Our Ref: AW/25/18/HH

**Town & Country Planning Act 1990 (as amended)
Town & country Planning (Development Management Procedure) (England) Order 2015
Application for Householder Planning Permission**

Development Two storey rear extension (resubmission following AW/271/17/PL). This application also lies within the parish of Pagham.
Location 36 Apple Grove Aldwick

North Elevation Proposed 1:100

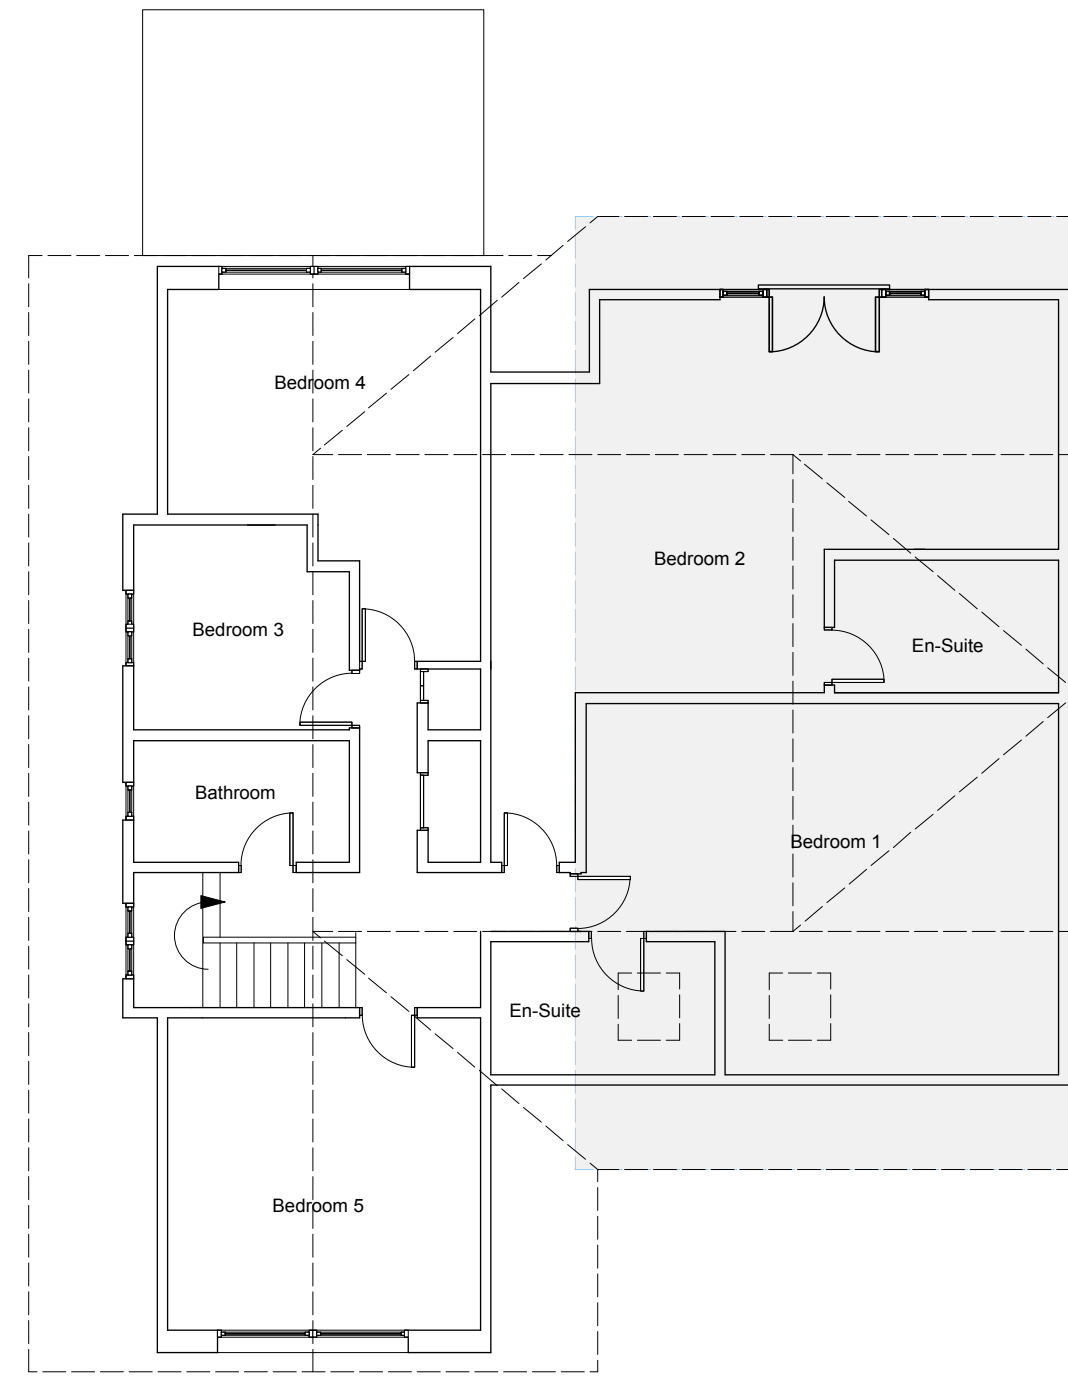
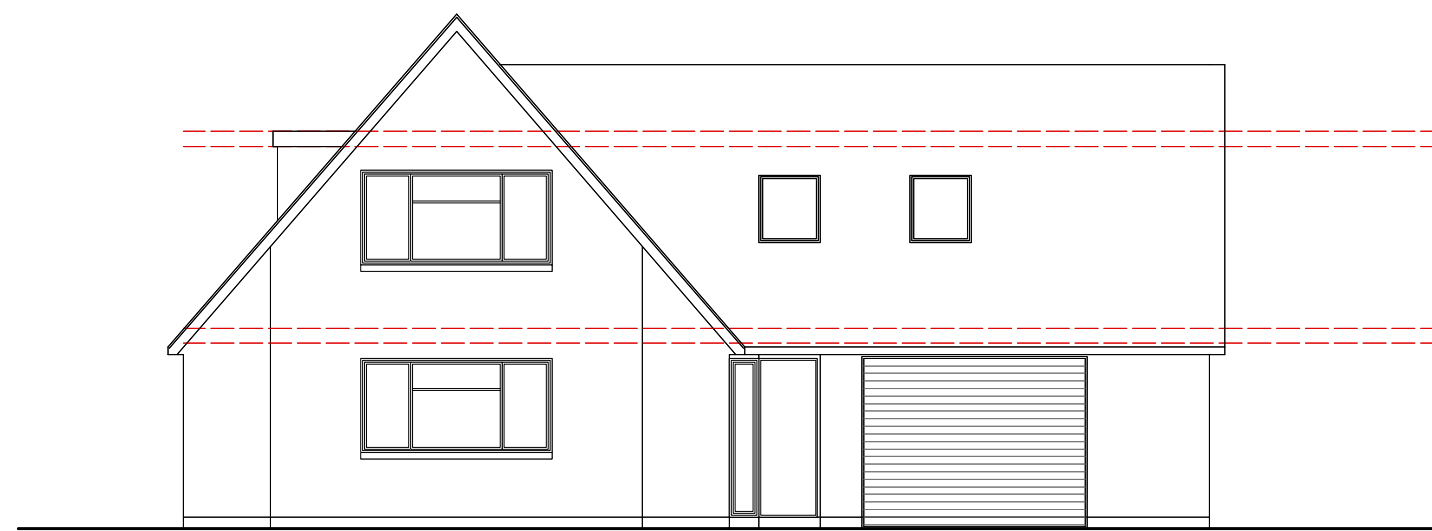
The proposed ground floor plan and north elevation do not accord. Please amend accordingly.

West Elevation Proposed 1:100

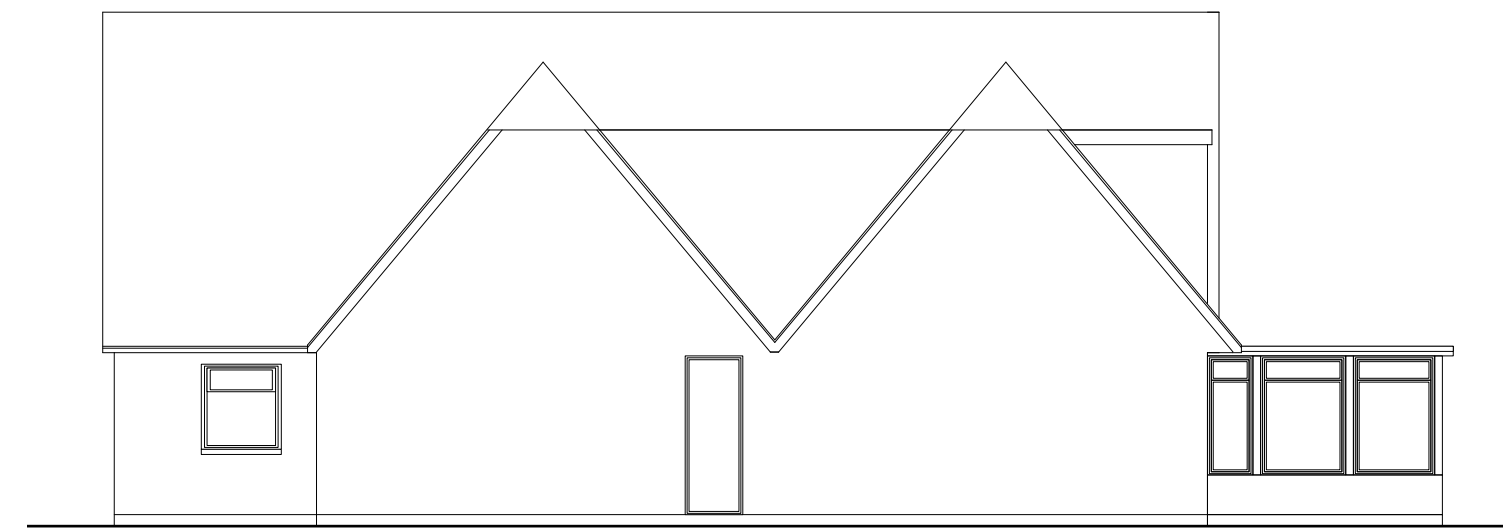
The proposed ground floor plan and west elevation do not accord. Please amend accordingly.
